Engineers Comments Regarding Surface Water Drainage

Application Reference:	P/110/25/DOC	Reviewer Reference:	ADC/Ext4
Planning Officer:	Simon Davis	Date of Review:	13/11/2025
Site Name:	Land West of Pagham Road Pagham Road Pagham PO21 3PY		
Application Description:	Approval of details reserved by condition imposed under reference P/178/21/OUT (APP/C3810/W/22/3302023) relating to condition number 11 - foul drainage system, condition number 12 - surface water drainage, condition number 13 - discharge rates of watercourses and condition number 14 - management and maintenance of surface water drainage system. (See P/109/25/DOC for condition number 17 - contamination, condition number 22 - internal noise level, condition number 24 - broadband provision, condition number 26 - bus stop information screens and condition number 28 - acoustic.).		
Assessment Number:	1 of 2

Response	Condition 12: Objection Condition 13: Objection Condition 14: Objection
-----------------	---

scale 1:500	drawn by FA	checked by SL
date APRIL 2025	cad file CONTRIBUTING AREAS PLAN	
title CONTRIBUTING HARDSTANDING AREAS PLAN

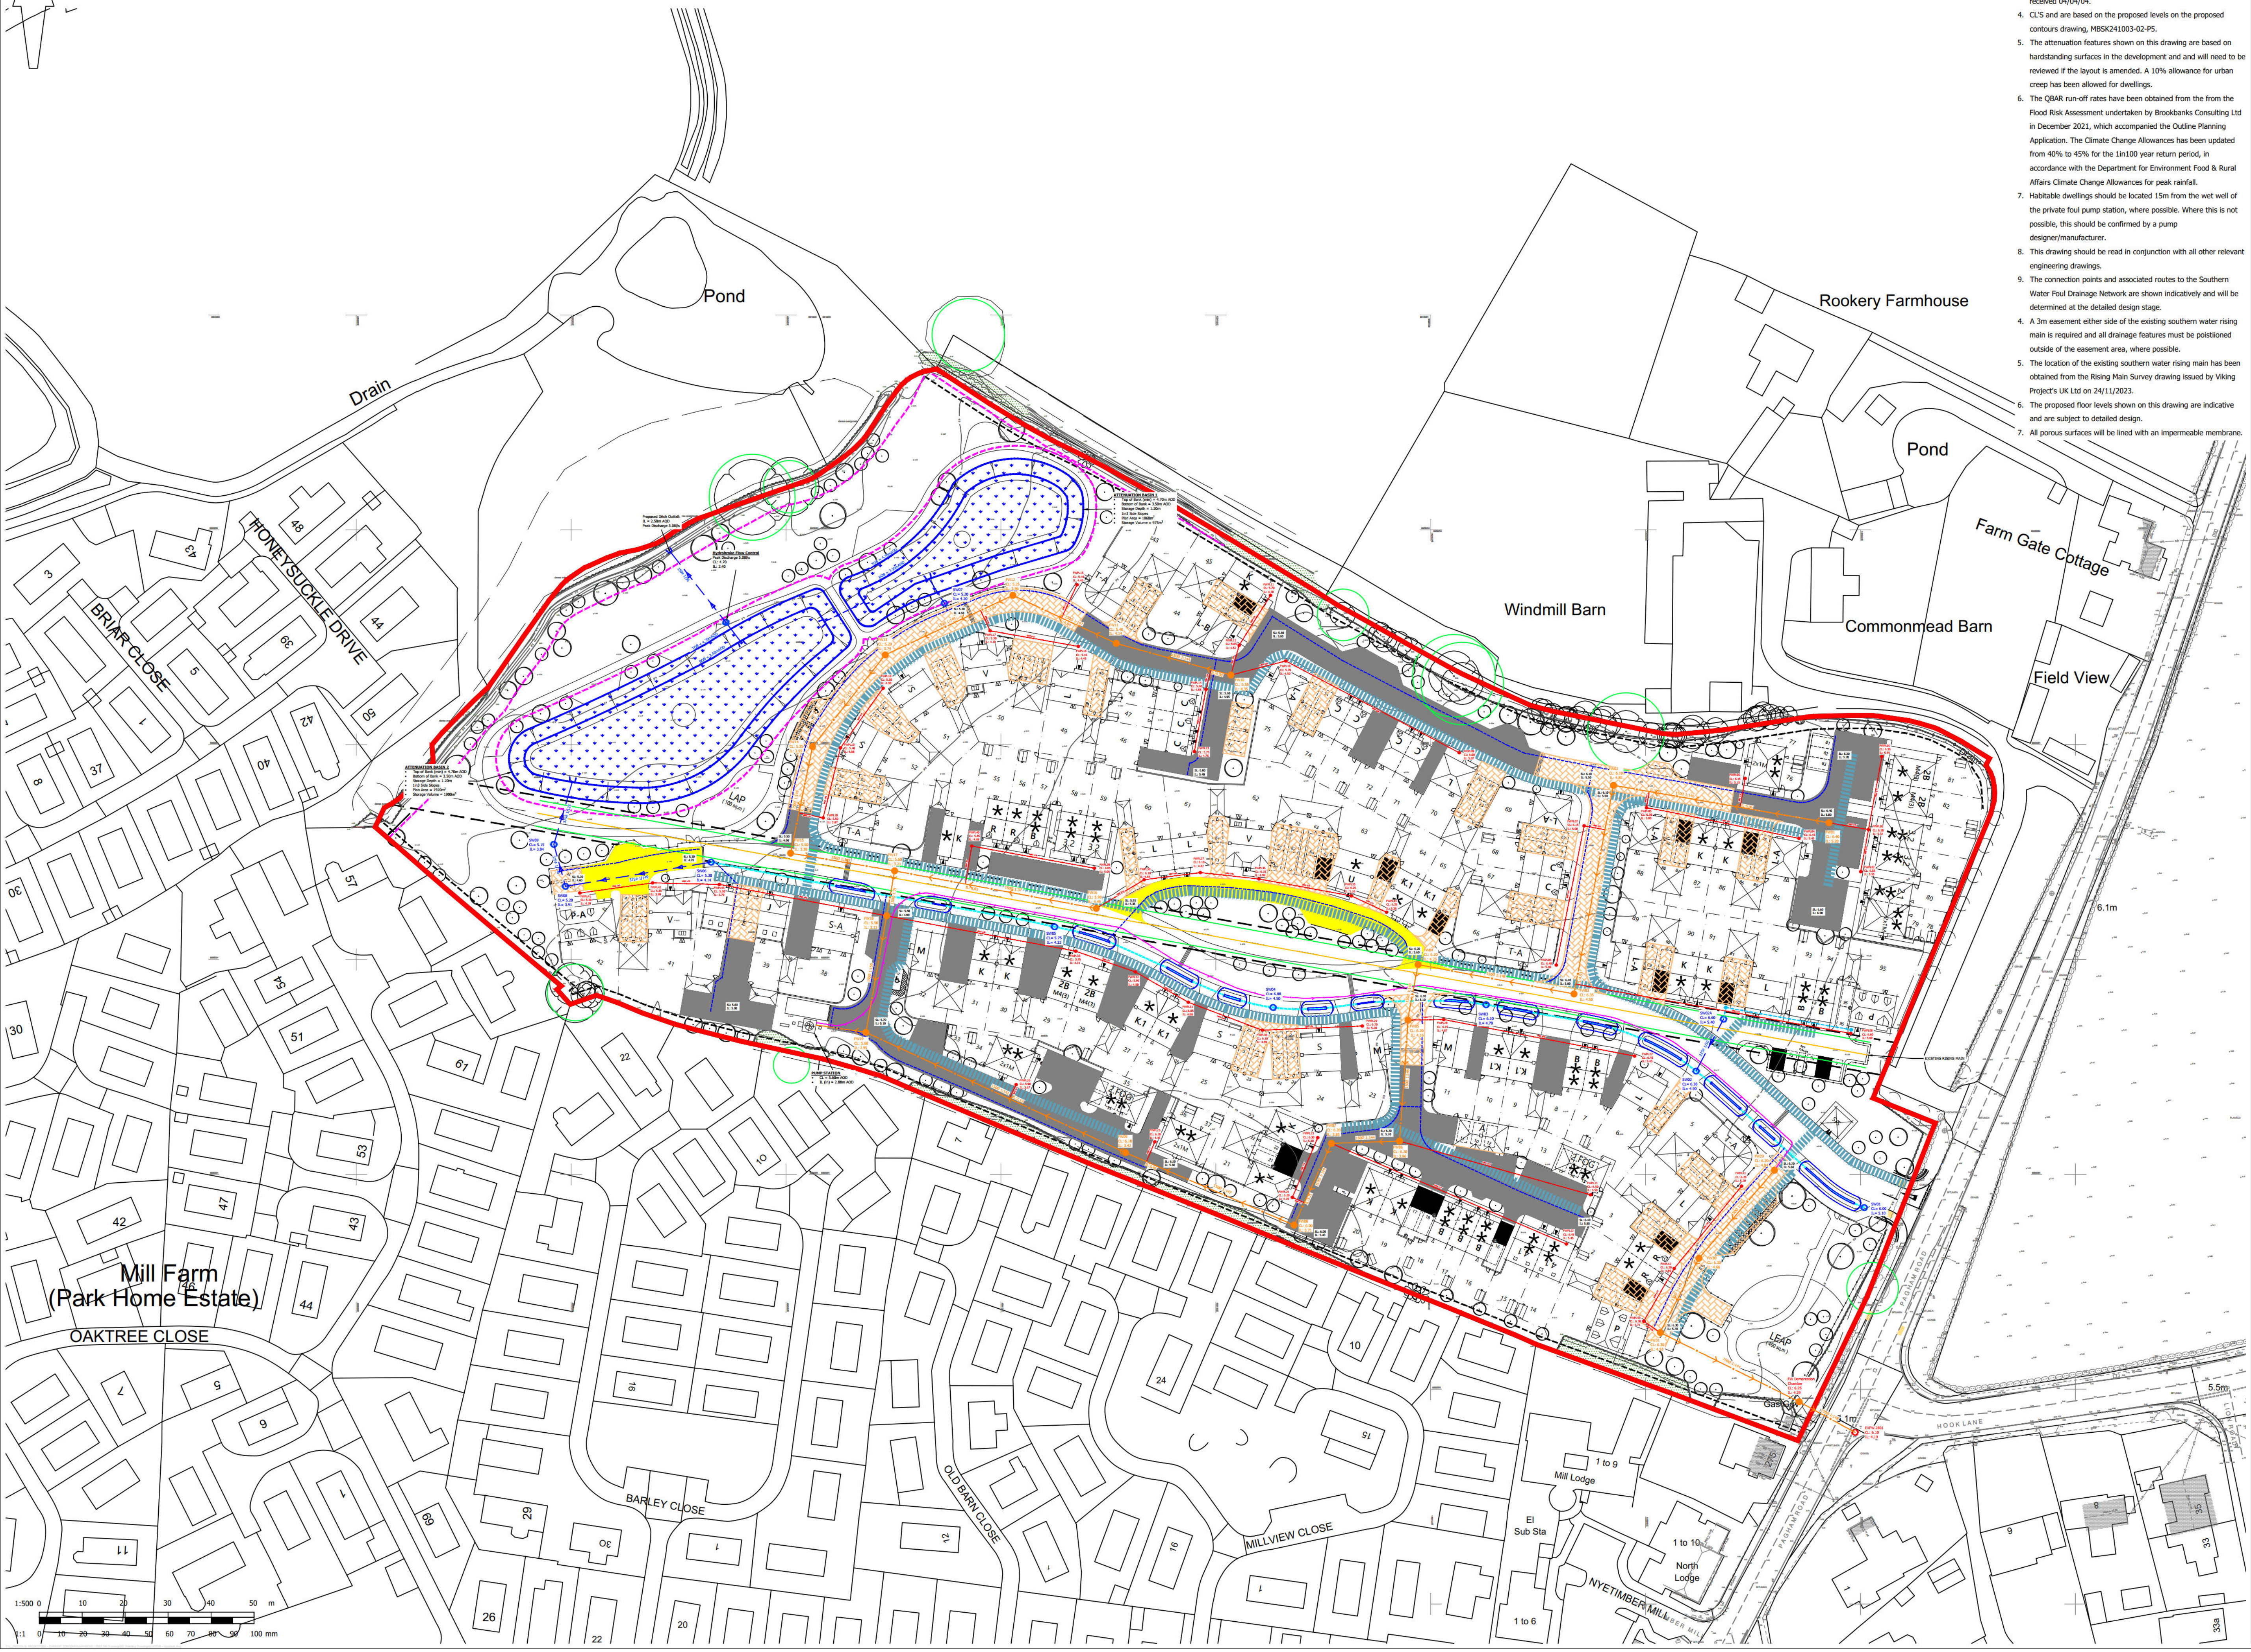
conditions, existing culverts etc... of the watercourse immediate downstream of the proposed point of discharge				
3.	Please provide further details on the contributing area catchment plan. Specifically provide a breakdown on which areas enter in specific pipes/manholes and making clear references to the pipe numbers/manholes on the plans and supporting calculations

TYPICAL CONVEYANCE SWALE SECTION

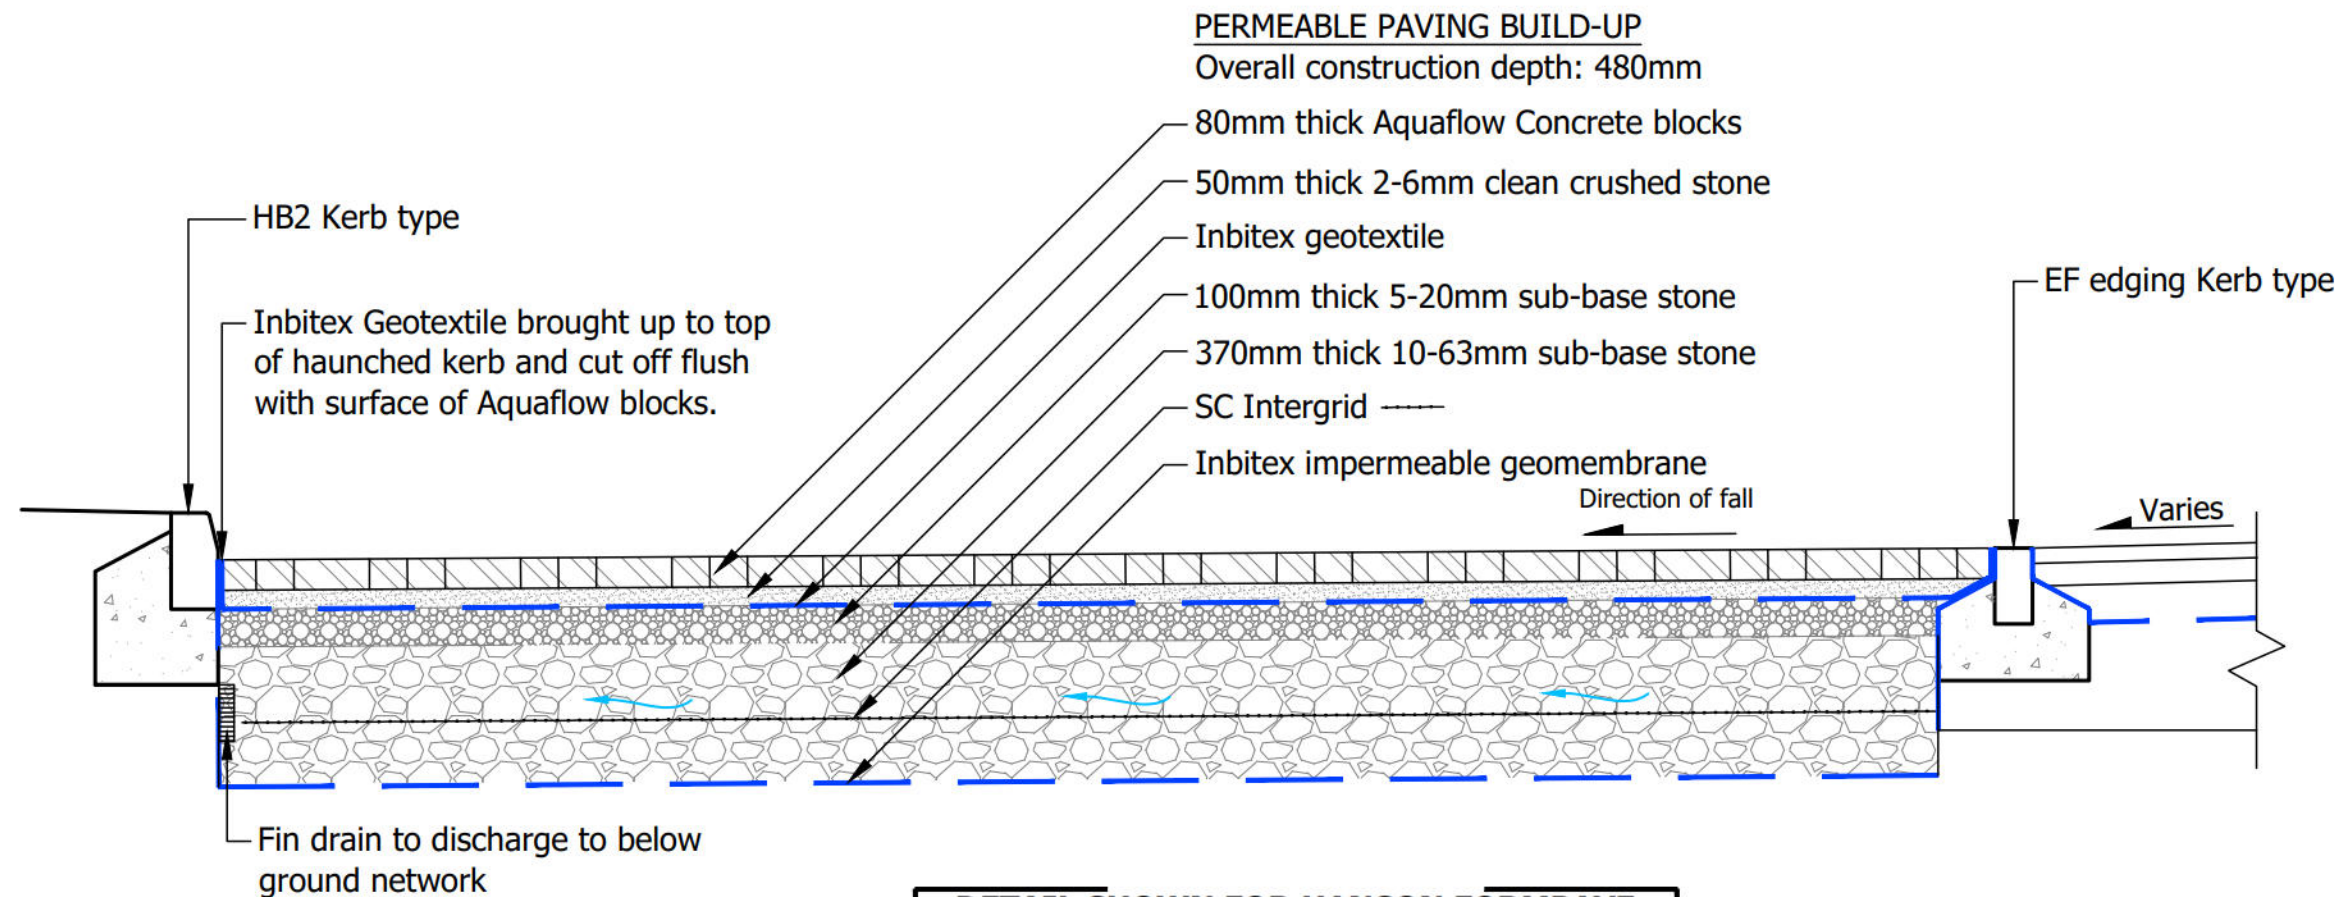
12.	The drainage details need to be provided at construction detail level. The current details provided are not specific enough and need to provide further information conducive to a construction level of detail

BAGWORK HEADWALL CROSS SECTION

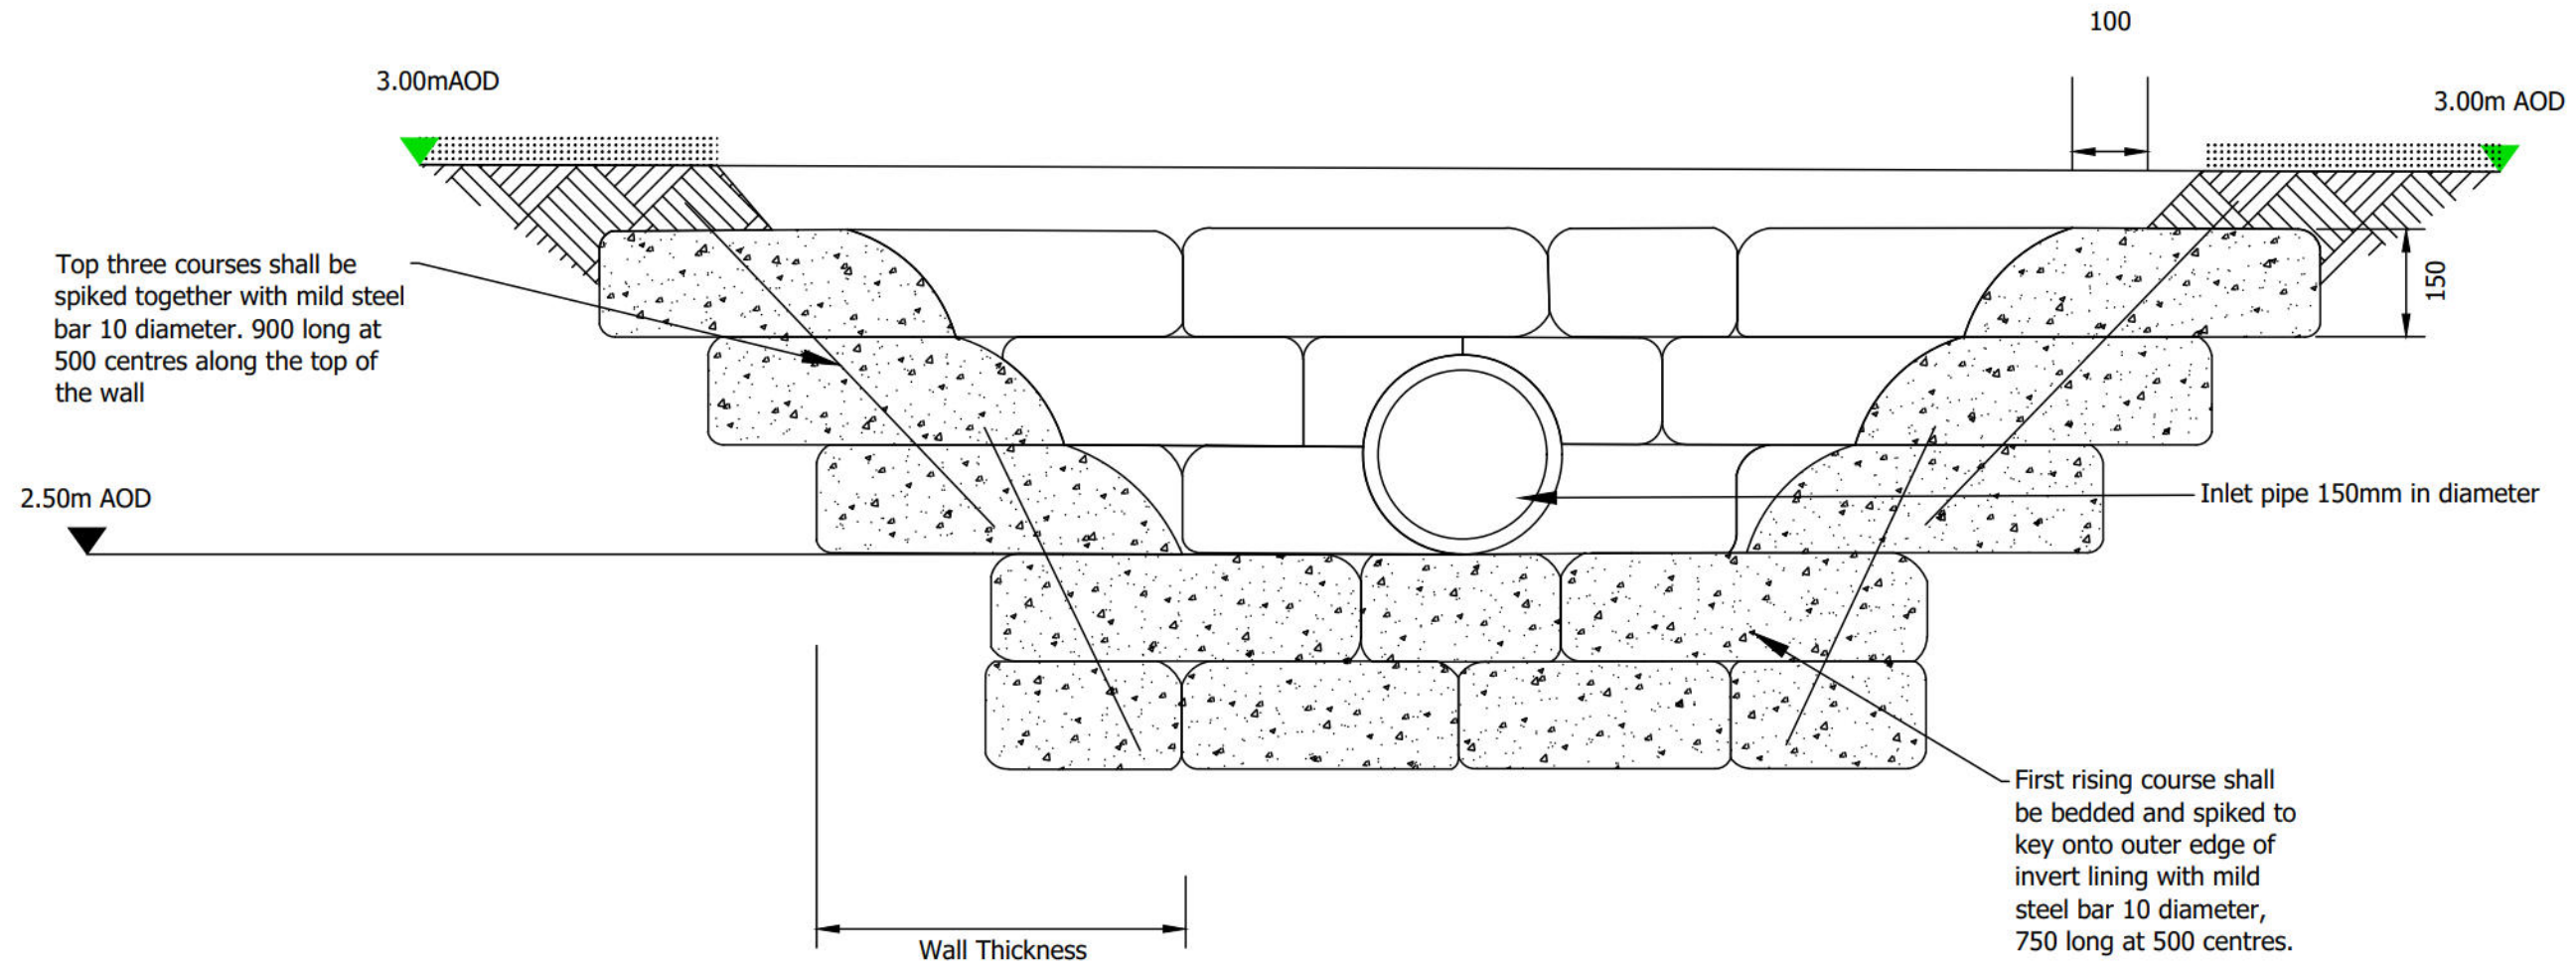
Comment Number					
1.	Please provide details of Ordinary Watercourse Consent in relation to the proposed new headwall connection to the existing ditch
